**COMMENT RESPONSES**

**1st Review**

<b>Project:</b>	<b>Solberg Pit - El Paso County Land Use Application</b>		
<b>Project Location</b>	Curtis Road & Garrett Road	<b>Prepared by</b>	Y2K Engineering
<b>Agency</b>	El Paso County	<b>Date of Report</b>	8/22/2023
<b>Reviewed By</b>	Daniel Torres	<b>Responses by</b>	Rae Stephani, PE, PTOE
<b>Date</b>	10/25/2023	<b>Date of Responses</b>	11/6/2023

# Solberg Pit - El Paso County Land Use Application Curtis Road & Garrett Road Traffic Impact Analysis

Figure 4: Site Plan

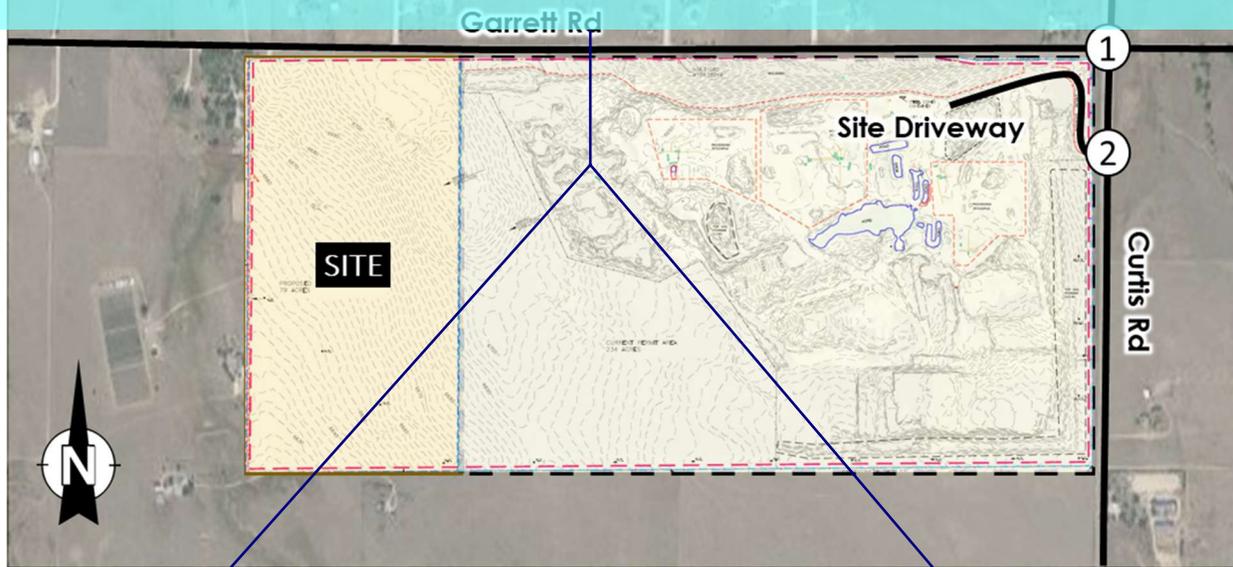
No	Agency	Page #	Comment By	Comment	Disposition		Comment Addressed By	Response / Comment
					Initial	Final		
1	El Paso County	1	DT	Should this be west on Garrett? Indicate the Haul vehicles destination from Garrett Rd. I assume that it is to Hwy 24 as opposed to another County Rd. Please state it in the report and clearly state that this is the intended Haul route. Also please indicate if all vehicles (haul vehicles & passenger car/truck) will utilize the same haul route.	A	A	RS	Yes, trucks will head west on Garrett. Clarifying text has been added to the report. The majority of haul vehicles will leave the site going north on Curtis Rd, and then turn west on Garrett Road. Hwy 24 is the destination from Garrett road as this route allows haul vehicles to deliver to the market in Colorado Springs. A small number of haul vehicles will leave the site and stay north on Curtis Rd to deliver material to the north or east of the site. Passenger cars/trucks will also use these routes.

The majority of haul vehicles will leave the site going north on Curtis Rd, and then turn west on Garrett Road. Hwy 24 is the destination from Garrett Road as this route allows haul vehicles to deliver to the market in Colorado Springs. A small number of haul vehicles will leave the site and stay north on Curtis Rd to deliver material to the north or east of the site. Passenger cars/trucks will also use these routes. The site plan is shown in **Figure 4** and is provided in **Appendix D**.
